**Department of Public Safety
STATE FIRE MARSHAL'S OFFICE**

Plan Review Summary

Name of Project: cPort Credit Union

Your drawings on the above subject project have been reviewed under NFPA 101 Life Safety Code 2009 Edition and all referenced publications: please submit new drawings indicating the below changes. Based on the comment responses, there may be follow up items to this review.

**A101**

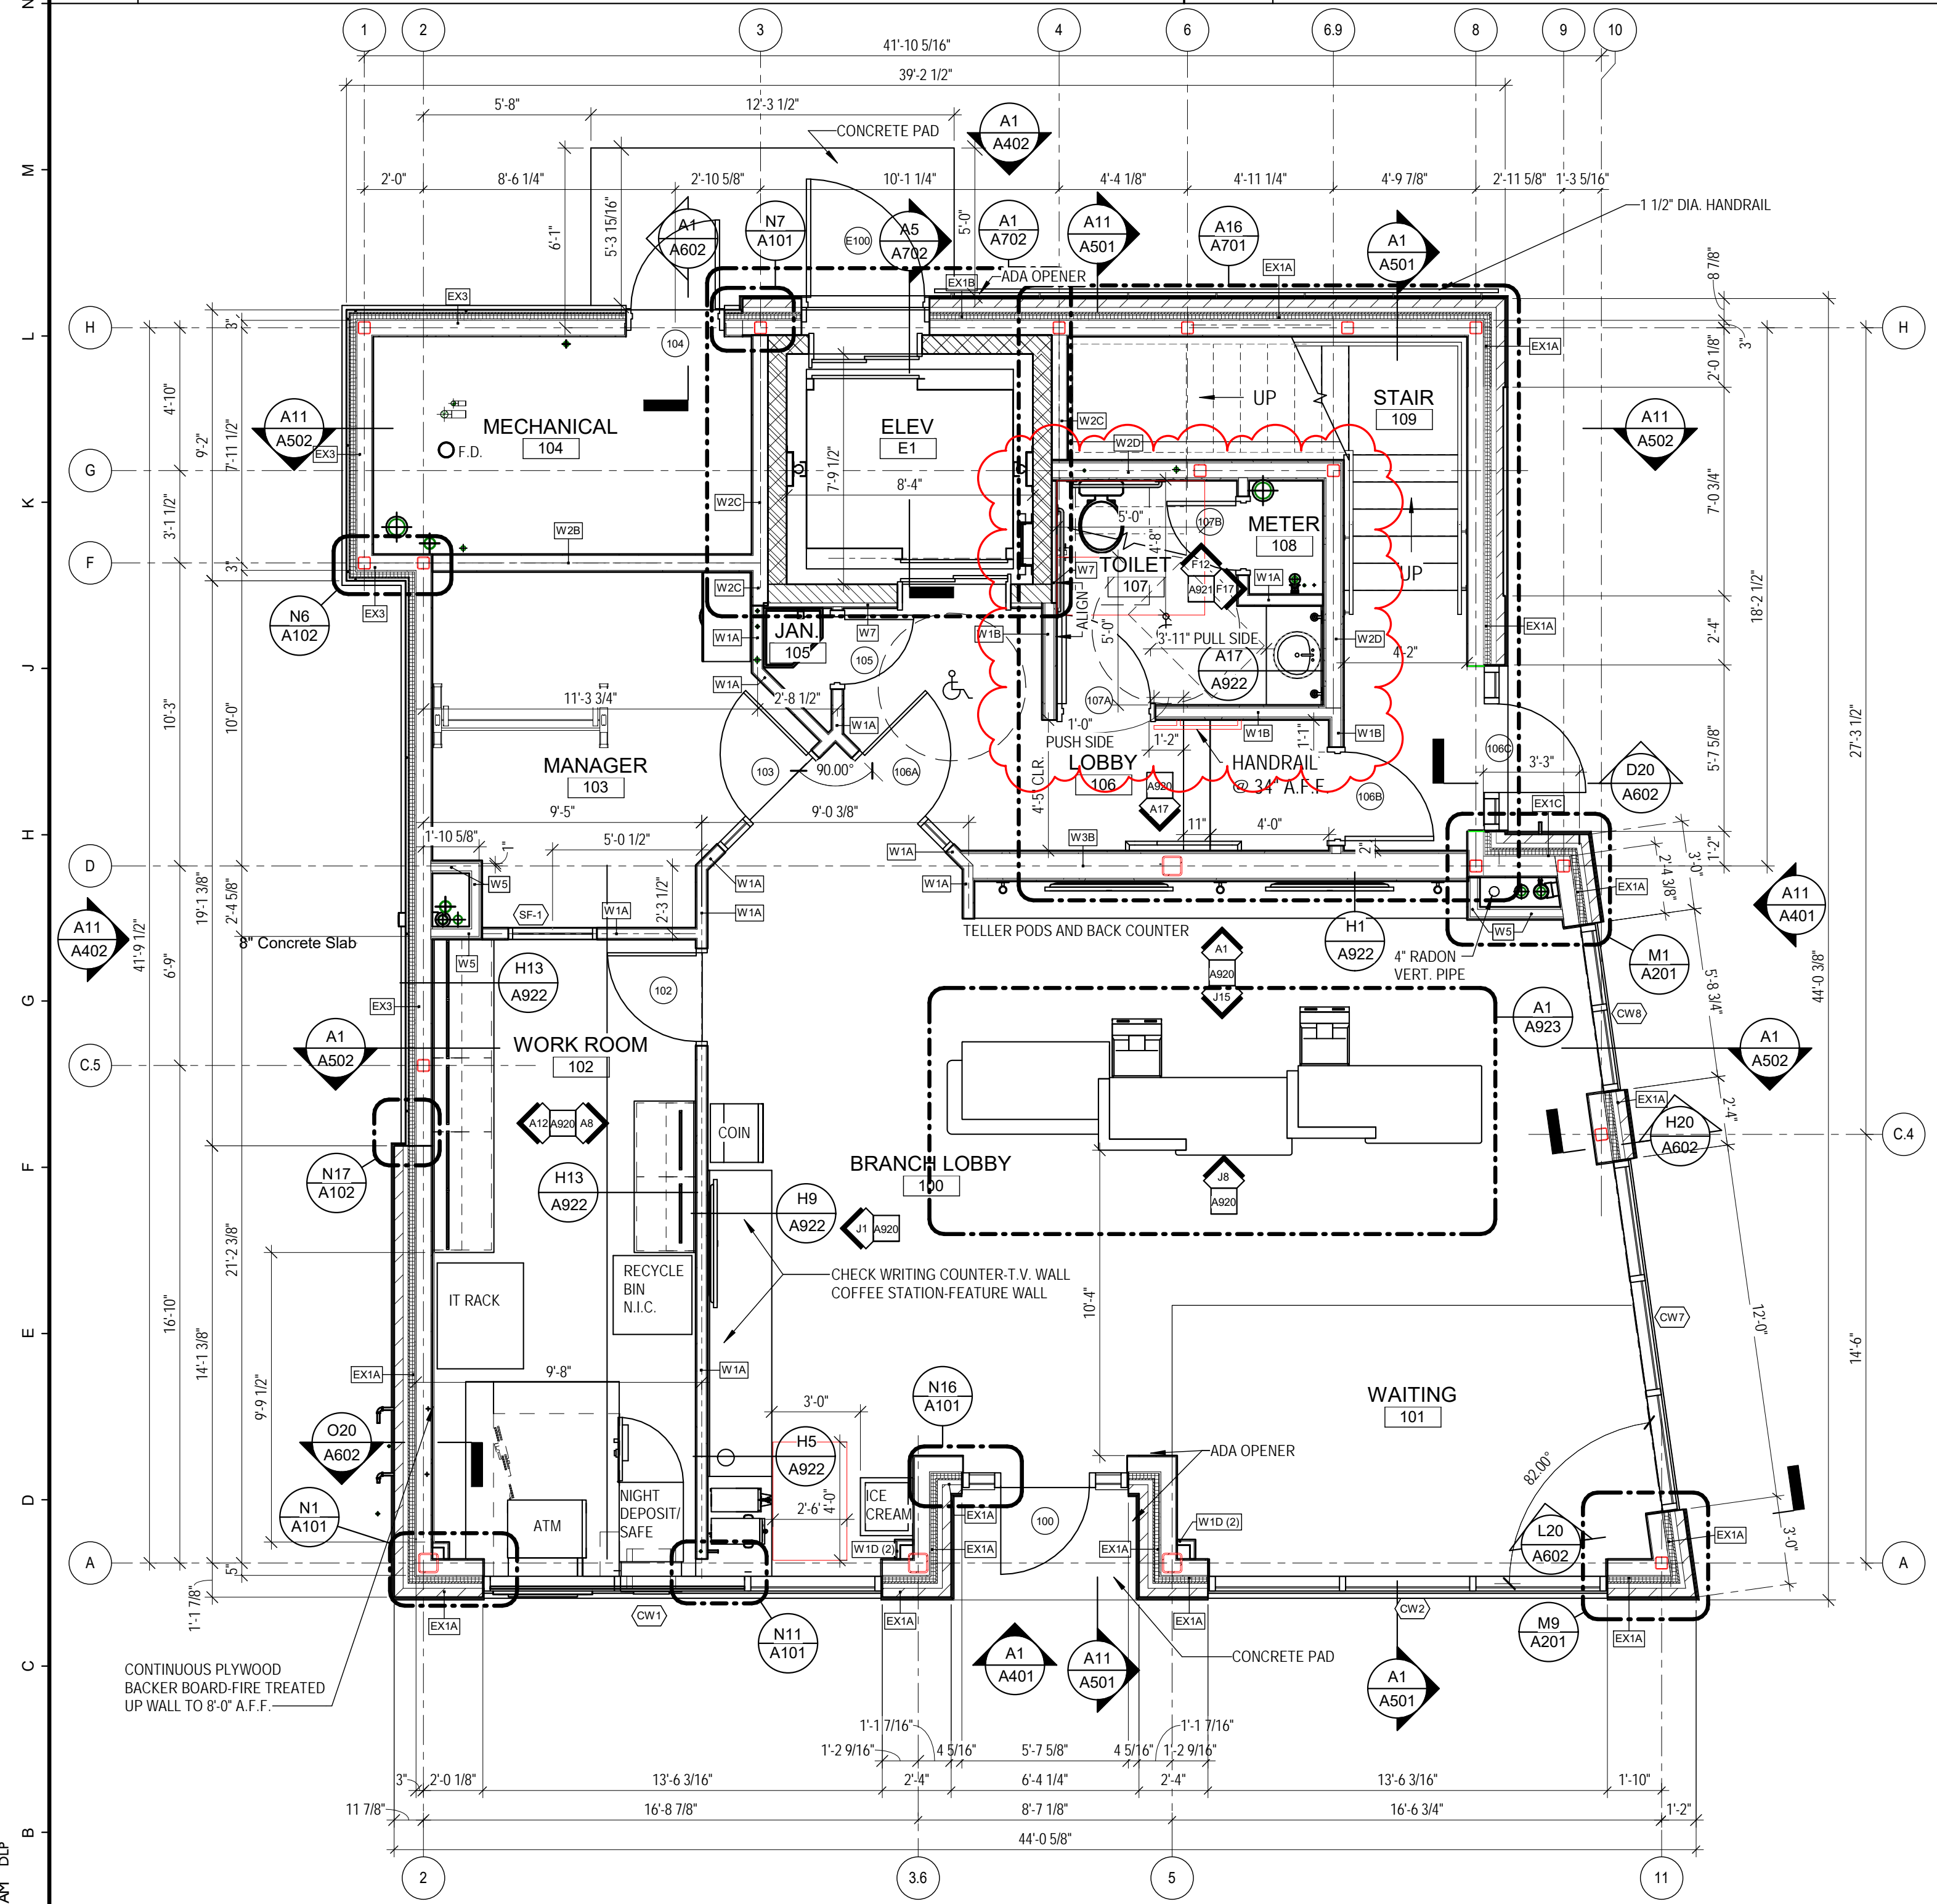
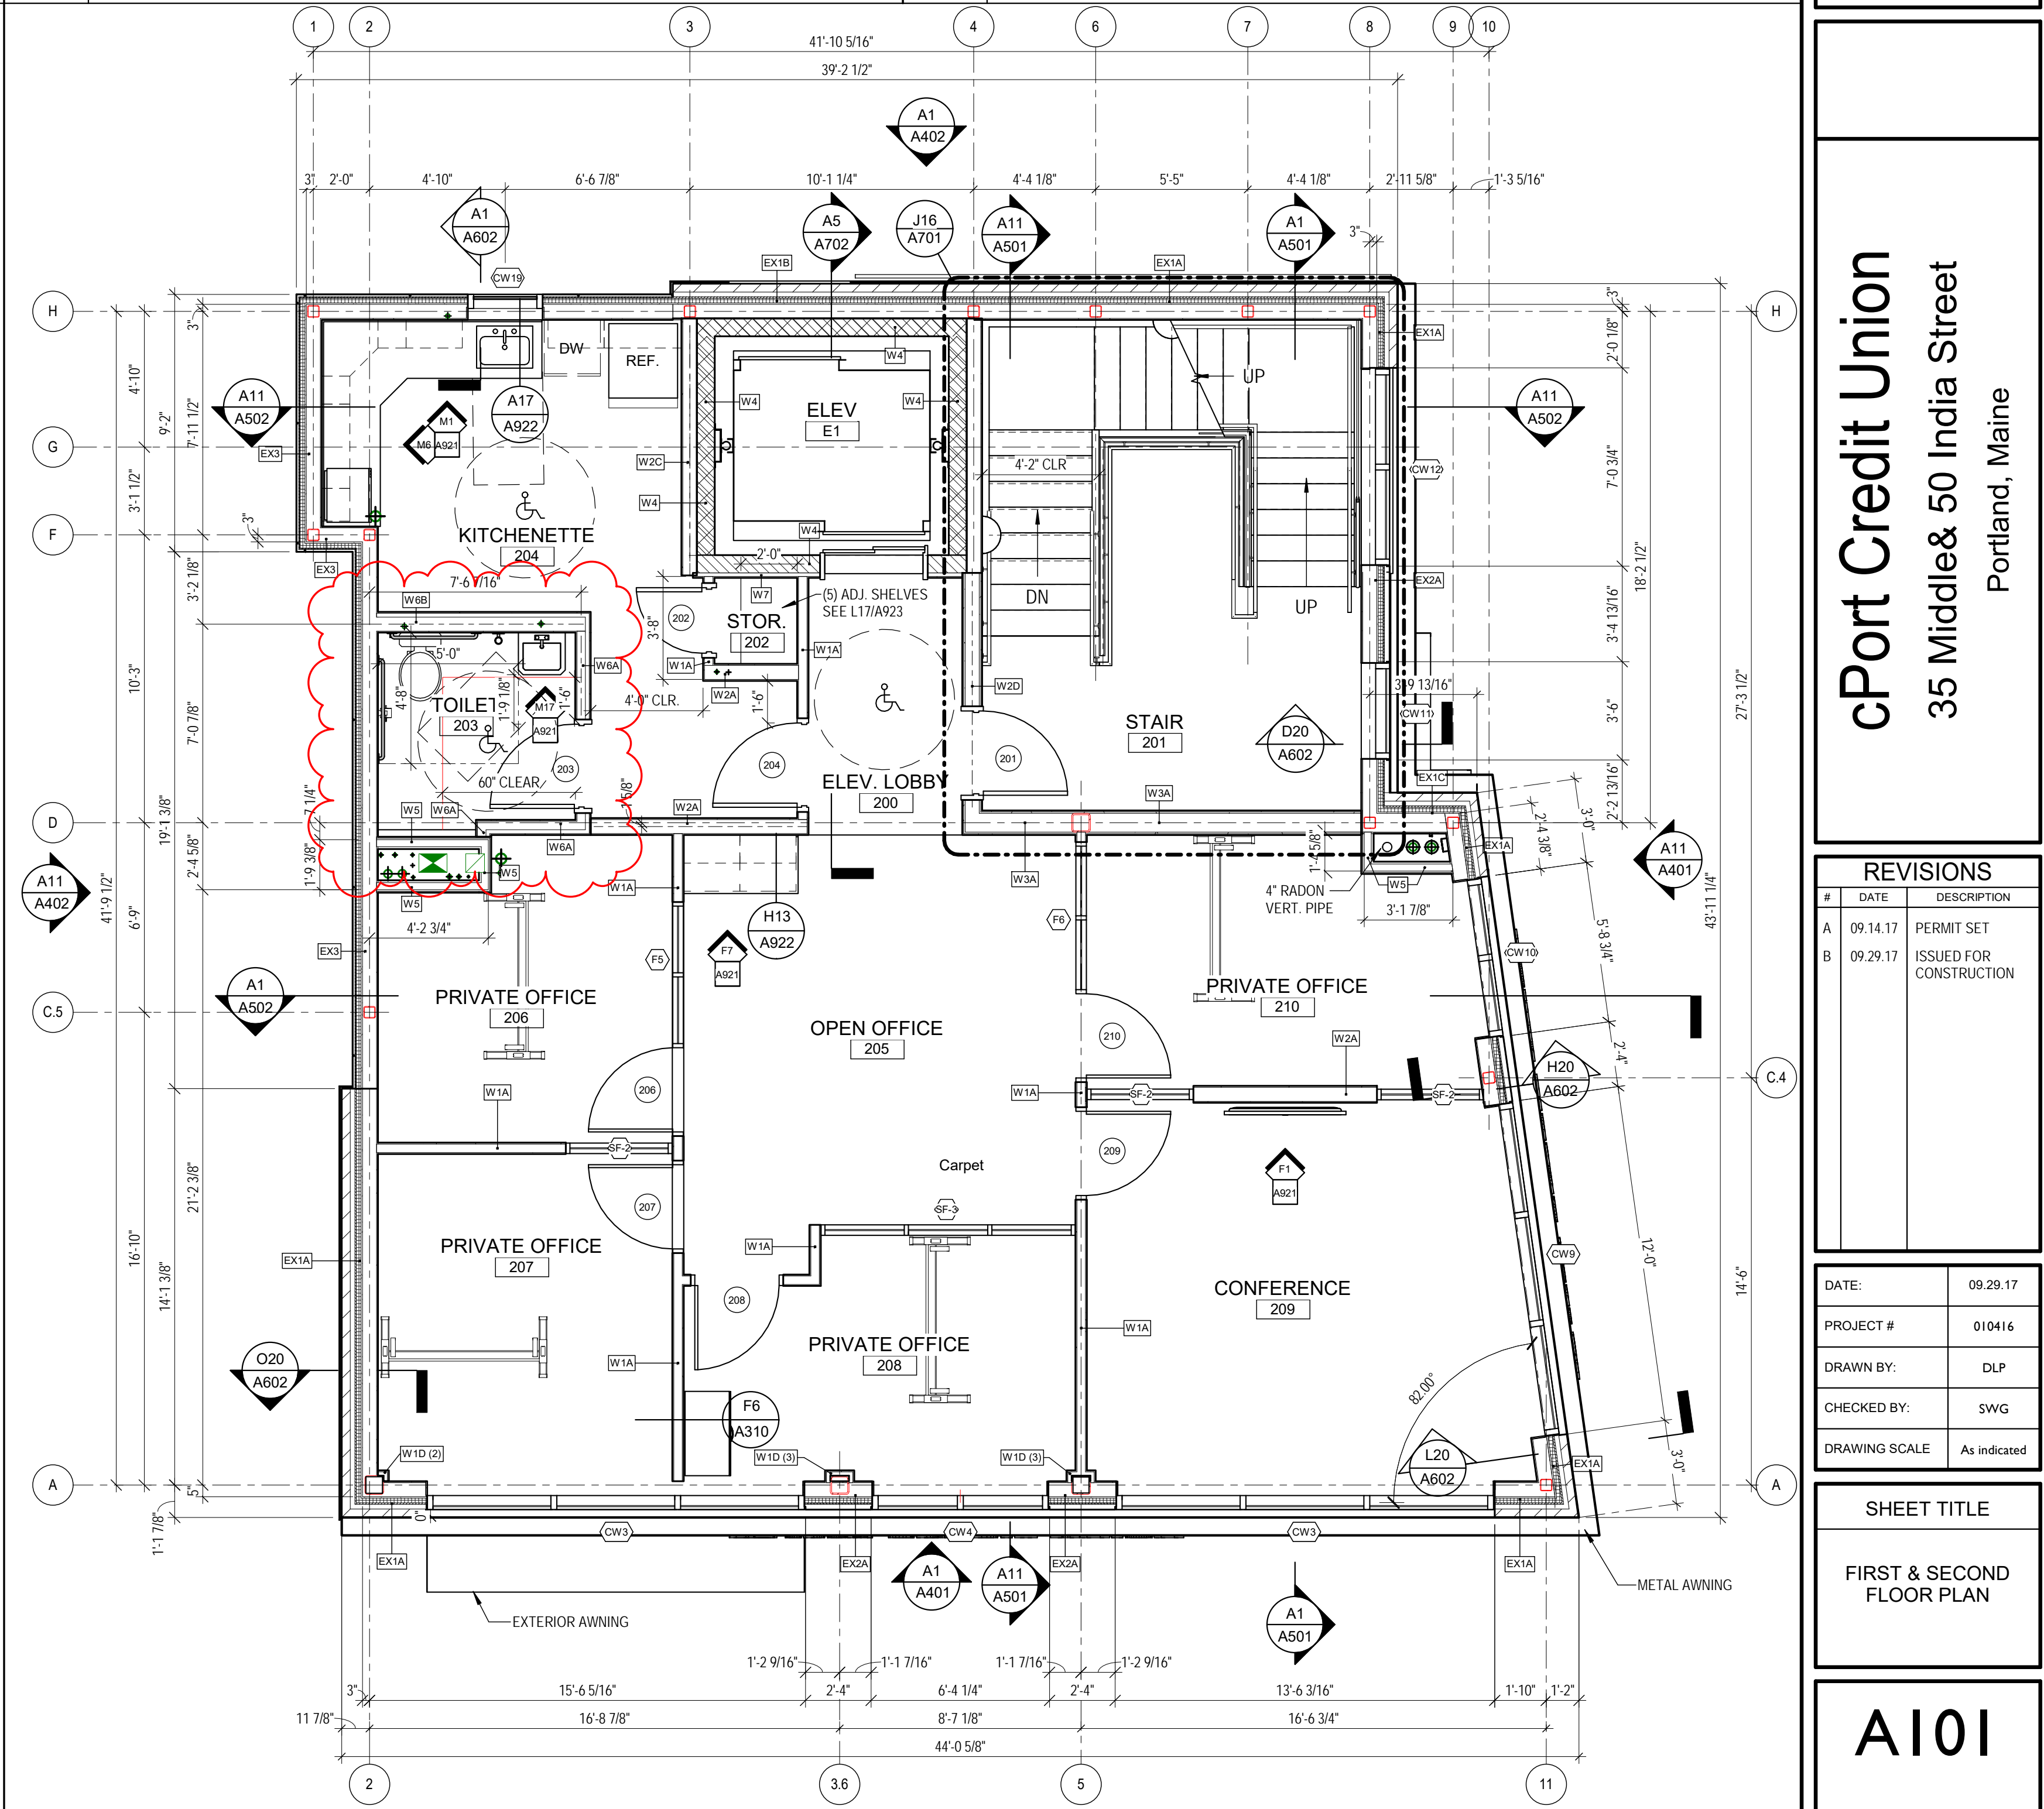
2. 2-hour wall at stair tower shown in detail M1/A201 on page A101 must main the 2 hour continuity to the exterior to protect the exposure to the stairwell The two layers of 5/8" type 'x' gwb will run continuous to the exterior of the wall. Detail M1/A201 will be updated to show the rating running continuous.
7.2.2.5.2.1 Where nonrated walls or unprotected openings enclose the exterior of a stairway, other than an existing stairway, and the walls or openings are exposed by other parts of the building at an angle of less than 180 degrees, the building enclosure walls within 10 ft (3050 mm) horizontally of the nonrated wall or unprotected opening shall be constructed as required for stairway enclosures, including opening protectives
